DEVIATION REQUEST AND DECISION FORM

Project Name :	Sterling Ranch Sand Creek Channel Construction Drawing Review CDR 20-4
Schedule No.(s) :	5227301021, 5233309027, 5228000030 & 38, 5233301001 5233301016 &17
Legal Description :	See Exhibit B – Legal Description

A deviation from the standards of or in Section **ECM section 3.3.3 Open Channel Design Standards** of the Engineering Criteria Manual (ECM) is requested for the Sand Creek Channel Design – Low Flow Channel Capacity.

Typical Channel Cross Section

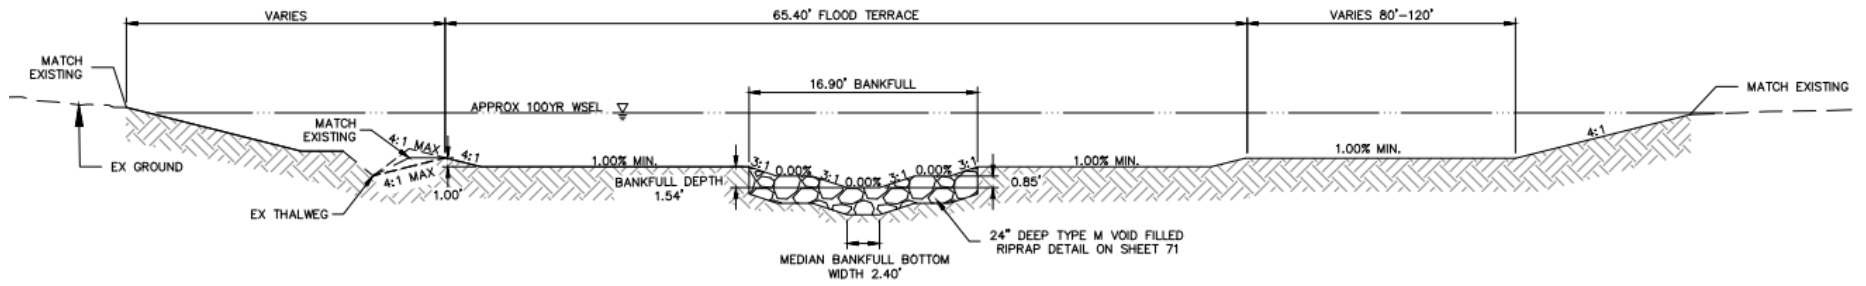
The geomorphology study recommended a much smaller “low flow” channel section.

See Exhibit A for a representation of the “geomorphologist recommended” low flow channel cross section.

The proposed low flow channel in the Sterling Ranch Sand Creek design is approximately 16.9 feet wide and 1.54 feet deep and has a capacity of 29 cubic feet per second. The low flow channel is armored with 24” deep type M void filled rip rap.

The geomorphologist's reasoning for the smaller low flow channel cross section was that base flows in this reach of the channel are a fraction of the ECM criteria. Base flows in this portion of Sand Creek are a fraction of the required low flow capacity and the required low flow channel would be far larger than necessary to deal with the base flows, eventually leading the channel to cut its own low flow section for base flows. By using a narrower multi-stage section within the bankfull, dense vegetation can establish itself, particularly along the inner berm. Instead of the bankfull being sized for the larger events, the flood terrace has been sized to convey the two year storm. The frequency that the flood terrace sees inundation will also allow for denser vegetation within the flood terrace extents. Since the bankfull will be carrying a smaller proportion of the larger events, the floodplain is wide enough to ensure that flow depth remains low outside of the flood terrace. Shear stresses in the overbanks are low enough that seeding and riparian plantings will be sufficient to withstand the high flow events, with only a few areas requiring more substantial treatment.

Maintenance of the low-flow channel shall be by the Sterling Ranch Metro District.

Full stabilization and vegetation density will be required prior to preliminary acceptance
